17 June 2016

RE: SSD 7056 – Remediation, Renewal and Adaptive Re-Use of Campbell's Stores, The Rocks

SSD 7056 – Renewal and Re-use of Campbell’s Stores, The Rocks – City of Sydney comments on Response to Submissions Report

Drawing Title  
**ELEVATIONS**  
JPW Project Number  
12006  
Drawing Status  
EA  
Drawing Number  
EA-A-2000  
Revision  
B

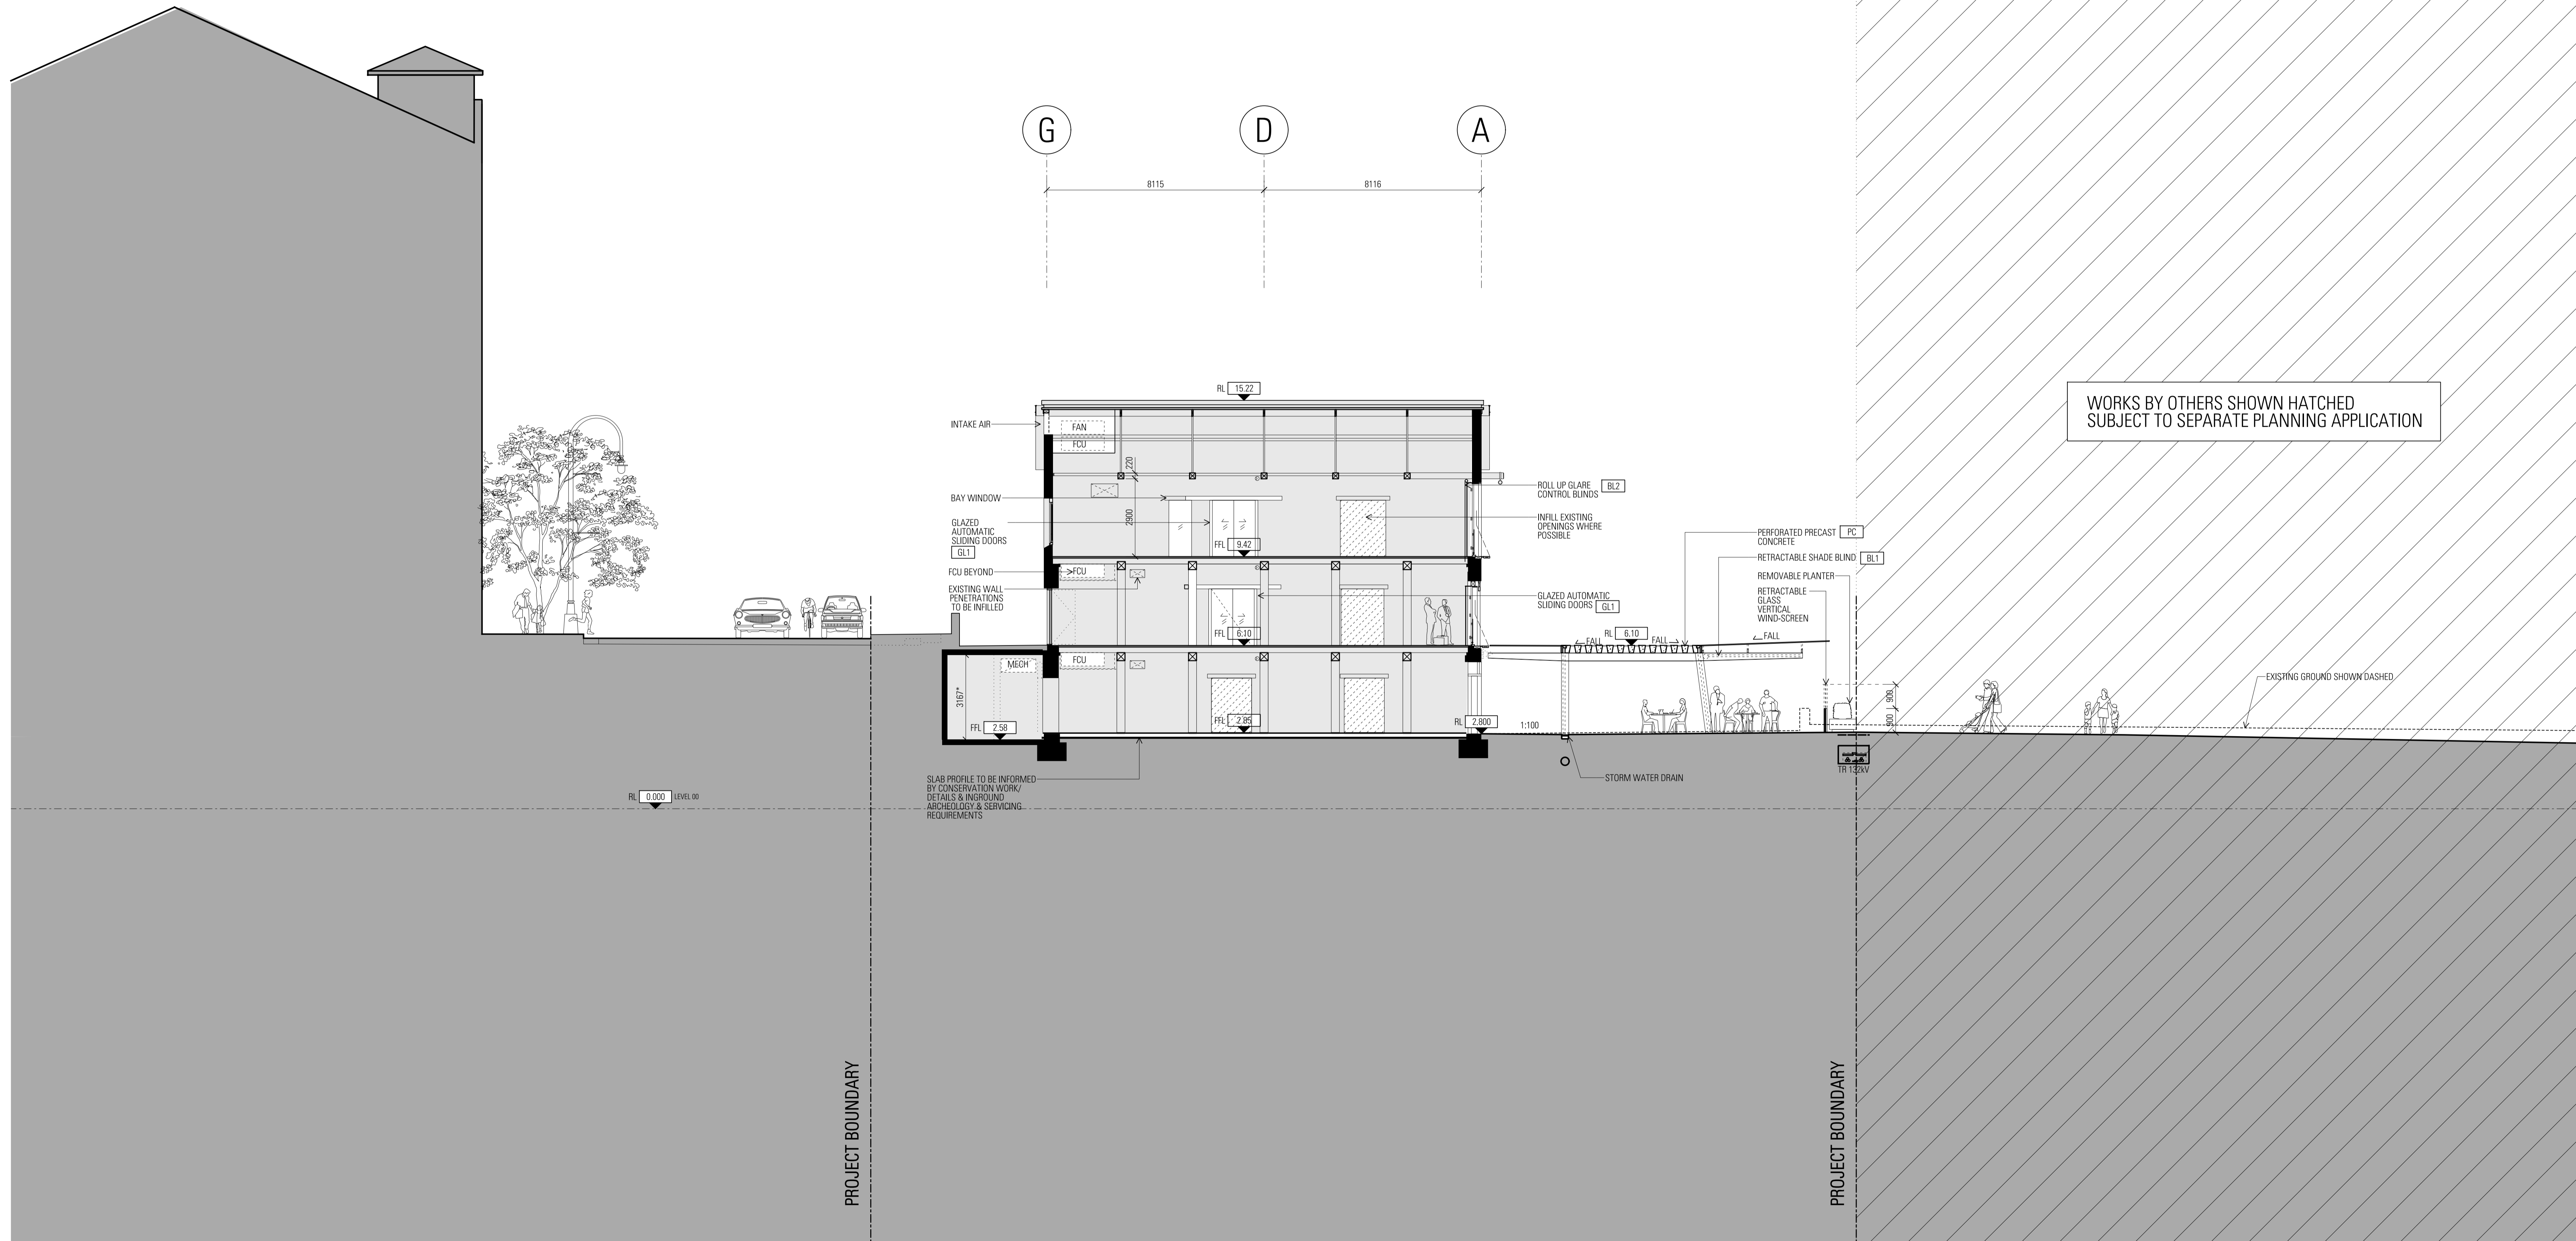
Planning and assessment issues			
Plans, elevations and images are not aligned for the “Bay 12” building. Clarification should be provided.	The design has been clarified. Slot windows have been removed and the drawings modified accordingly.	Yes	No further commentary.
